Application Ref:	3/2026/0253			 Ribble Valley Borough Council www.ribblevalley.gov.uk				
Date Inspected:	N/A	Site Notice:	N/A					
Officer:	AR							
DELEGATED ITEM FILE REPORT:					APPROVAL

Development Description:	Lawful development certificate for proposed single storey rear extension.
Site Address/Location:	30 Rogersfield Langho Lancashire BB6 8HB

PL.00.01 - Proposed plans and elevations

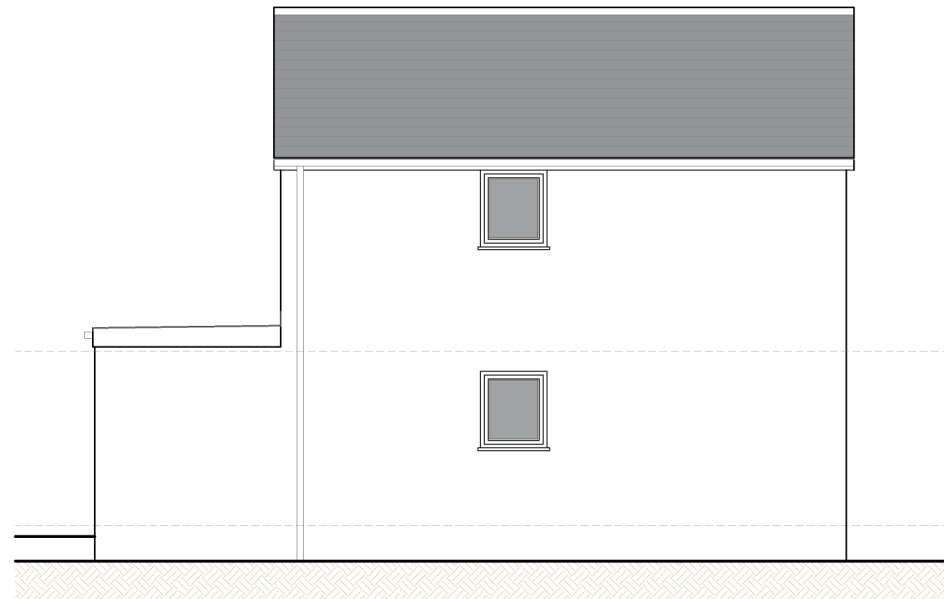
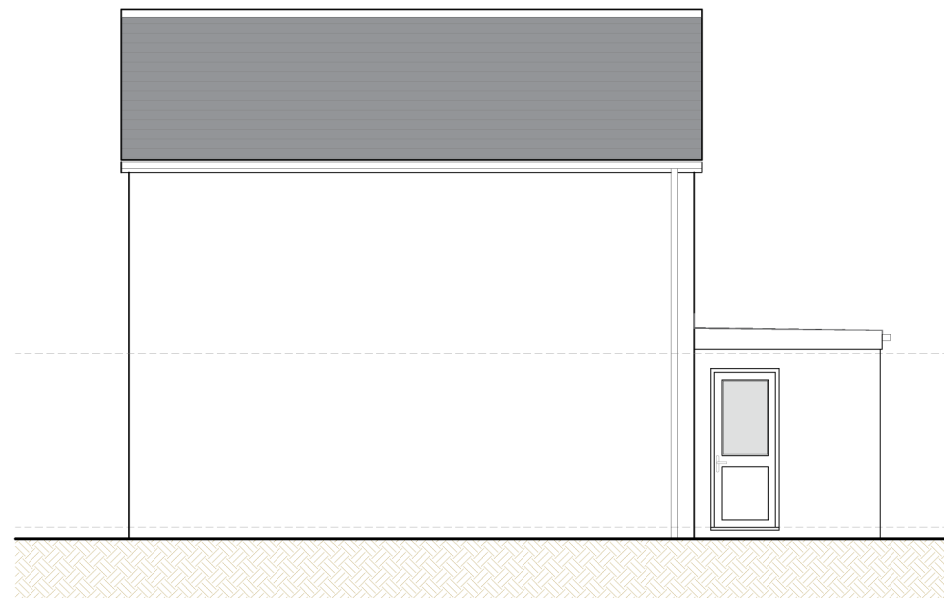
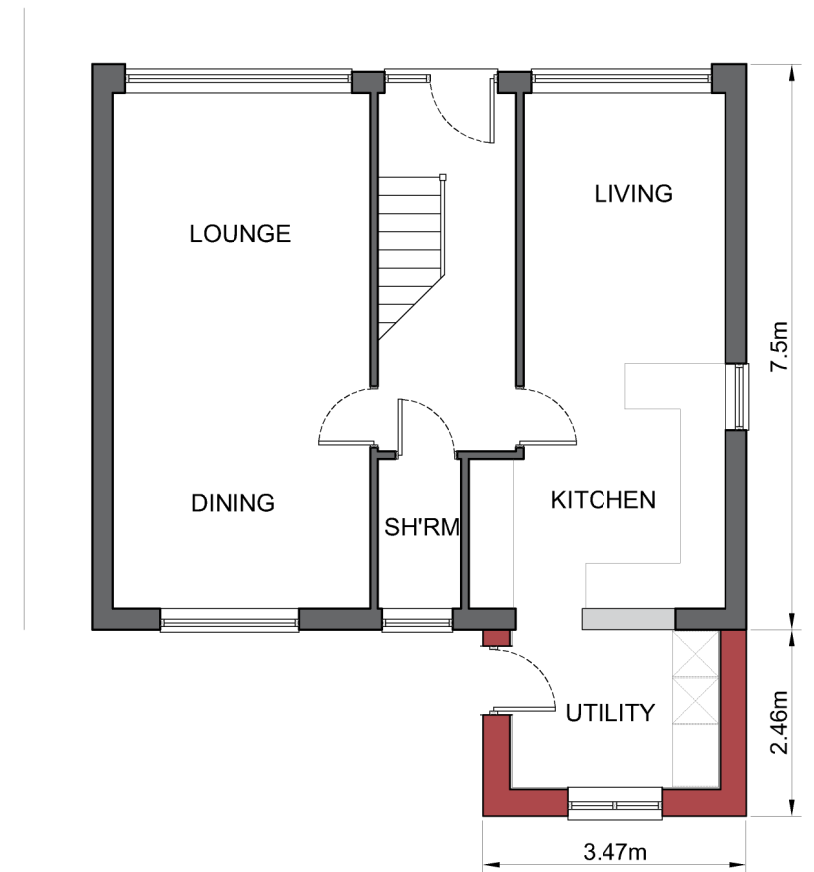
Consent is sought for a Certificate of Lawfulness for the construction of a single-storey rear extension. The proposed extension would project off the dwelling's rear elevation by 2.46m and have a width of 3.47m

with a maximum height of 3.1m. The proposed extension would feature a window to its rear elevation and a door to its side elevation.

The height of the proposed single storey extension would not exceed the height of the existing dwelling.

The proposed extension(s) would not project more than 4m from the rear wall of the detached dwellinghouse and would not exceed 4m in height.

The proposed extension would not be within 2m of the boundary of the curtilage.

The enlarged part of the dwellinghouse would not extend beyond a wall forming a side elevation of the original dwellinghouse.

The proposed extension would be finished in materials to match the existing dwellinghouse.
